29/03/2022

Taronga Wildlife Hospital Nutrition Centre (SSD-17655146)

Response to Submissions

Drawing Number
AA-N2001

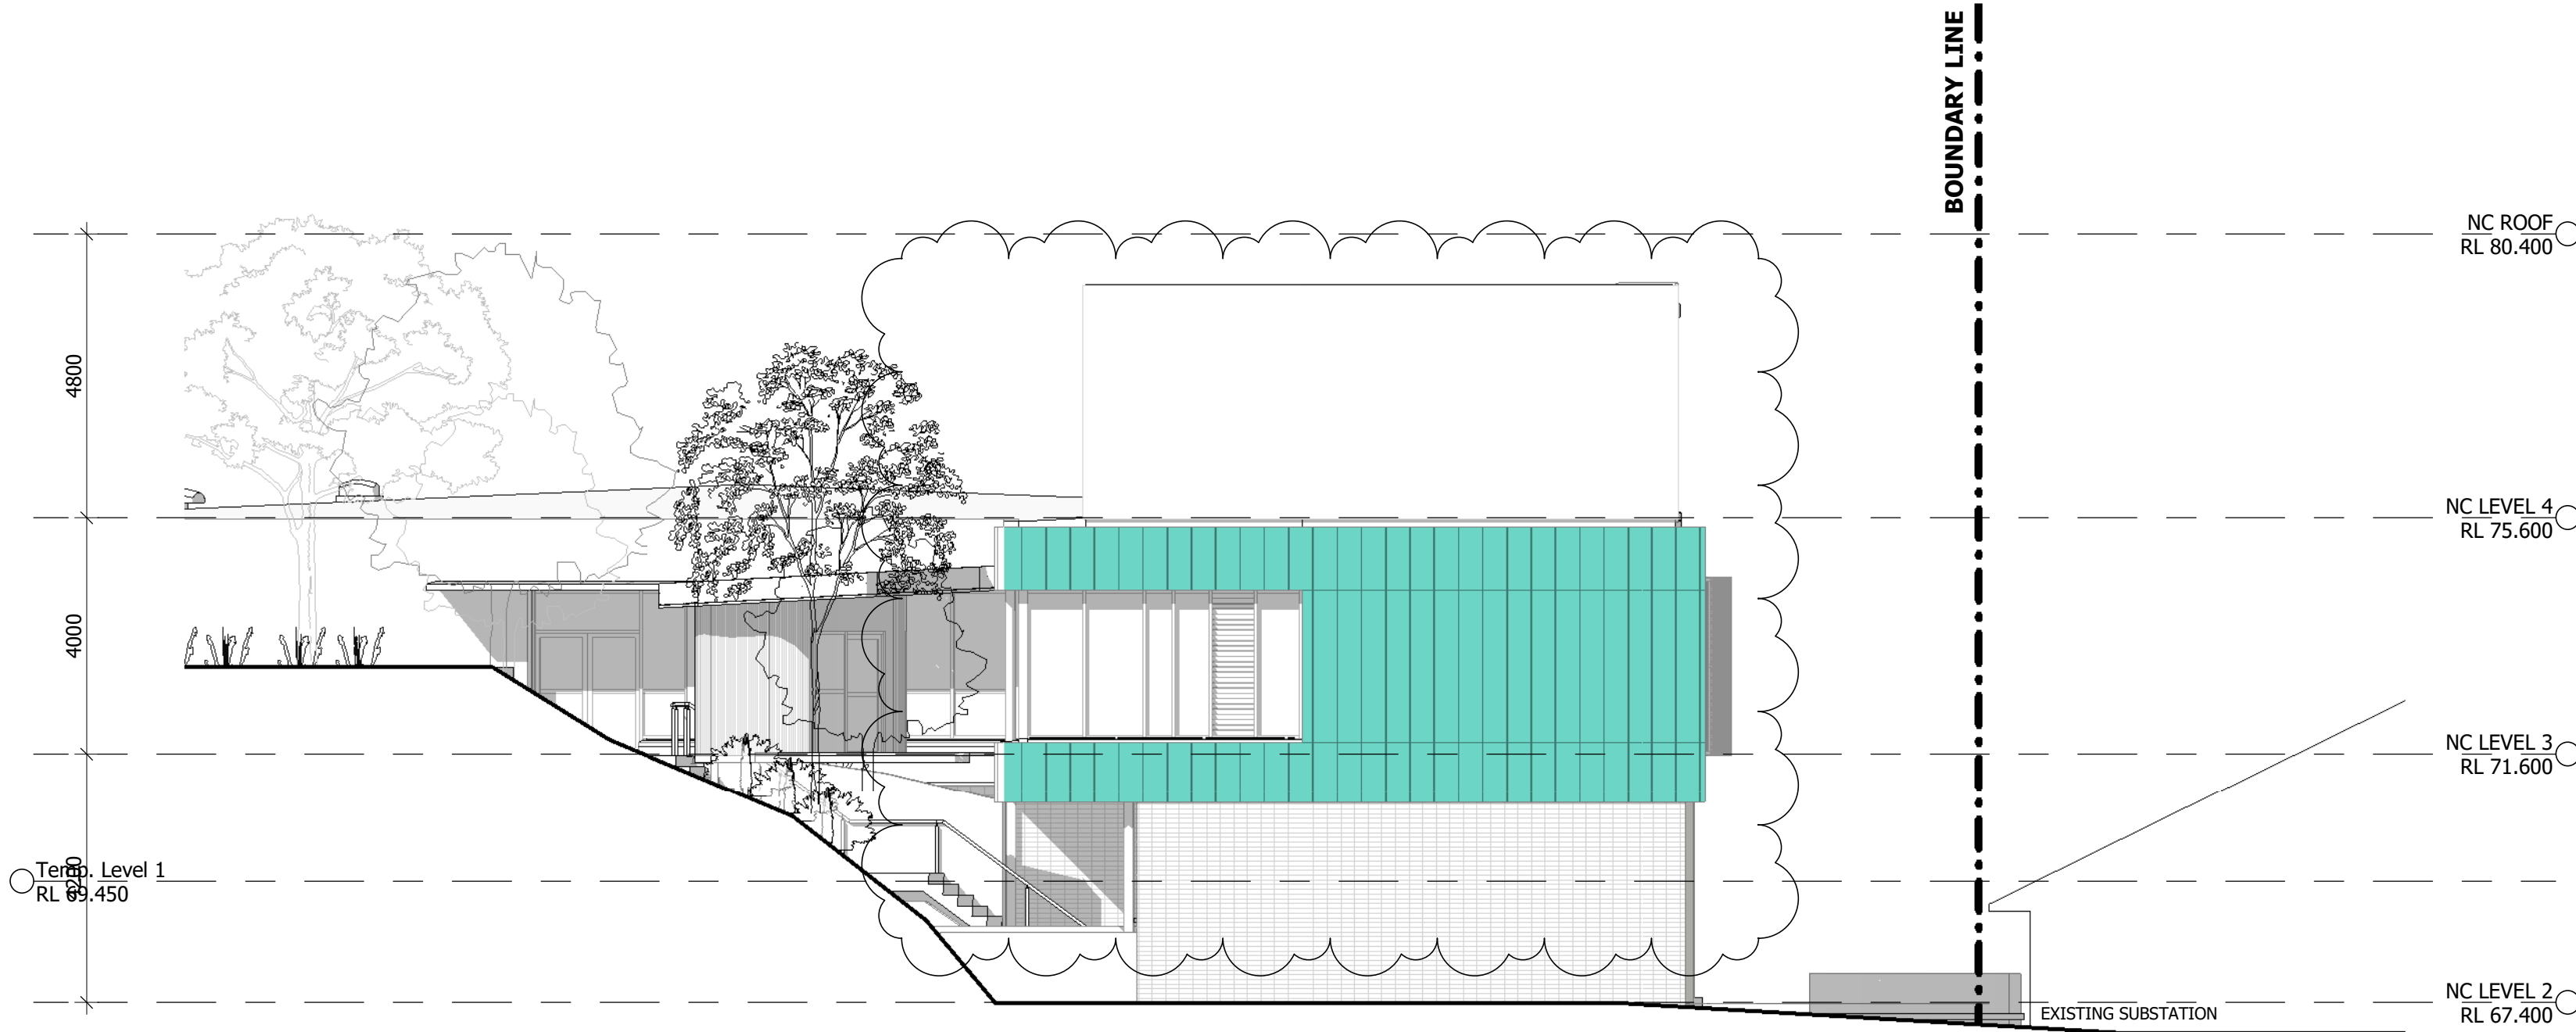
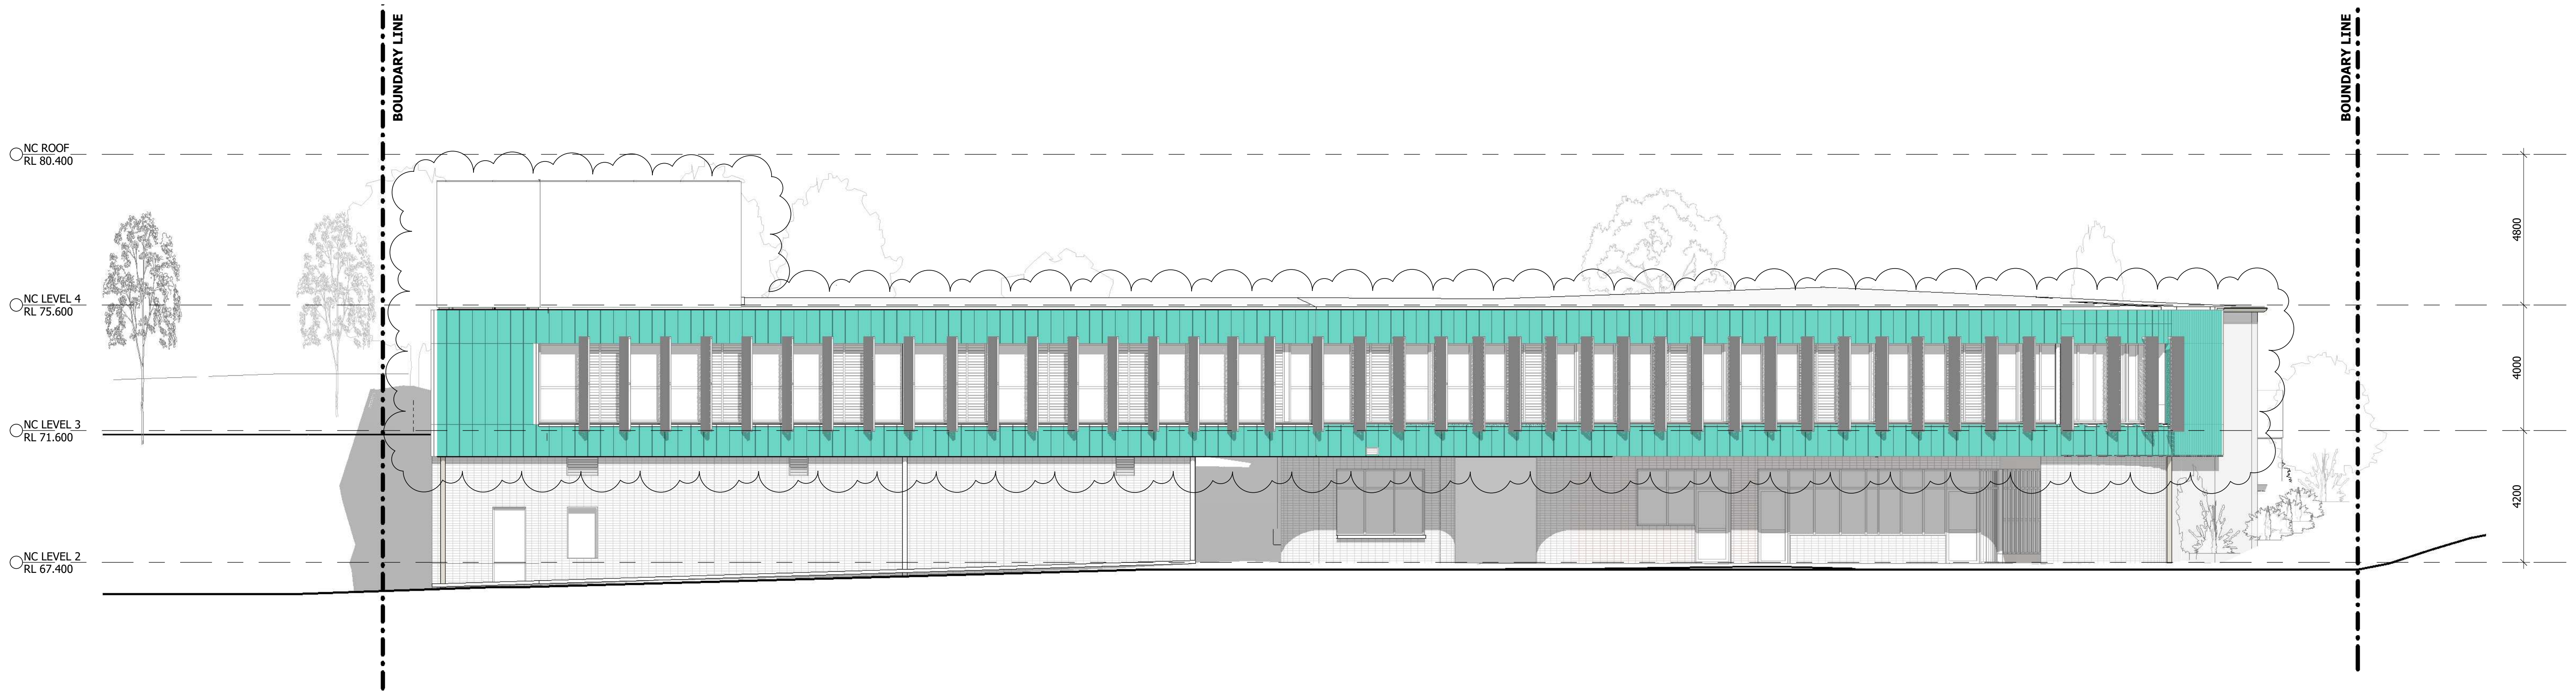
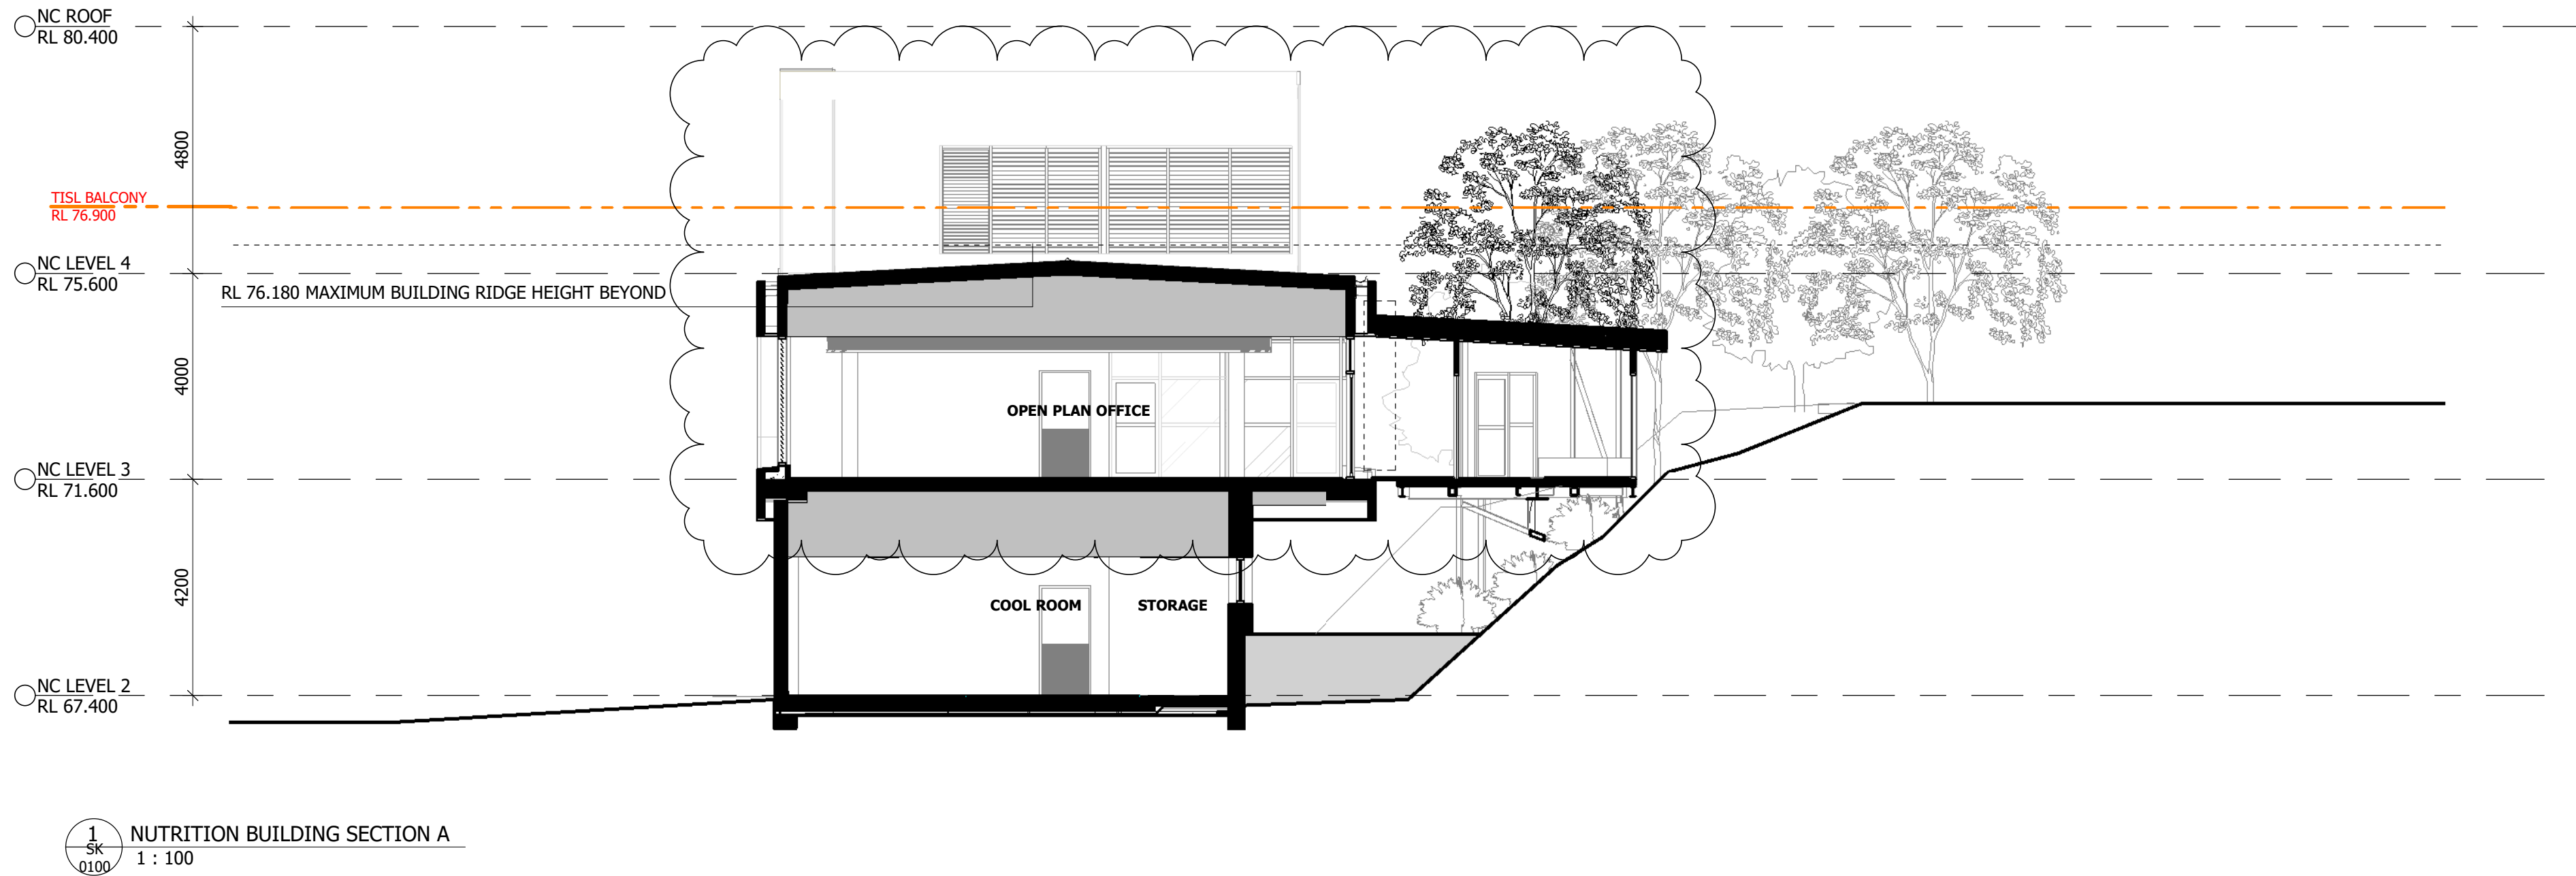
9. As stated in the EIS, signage is not to be assessed as part of the application. Elevation plans showing any proposed signage should omit signage.
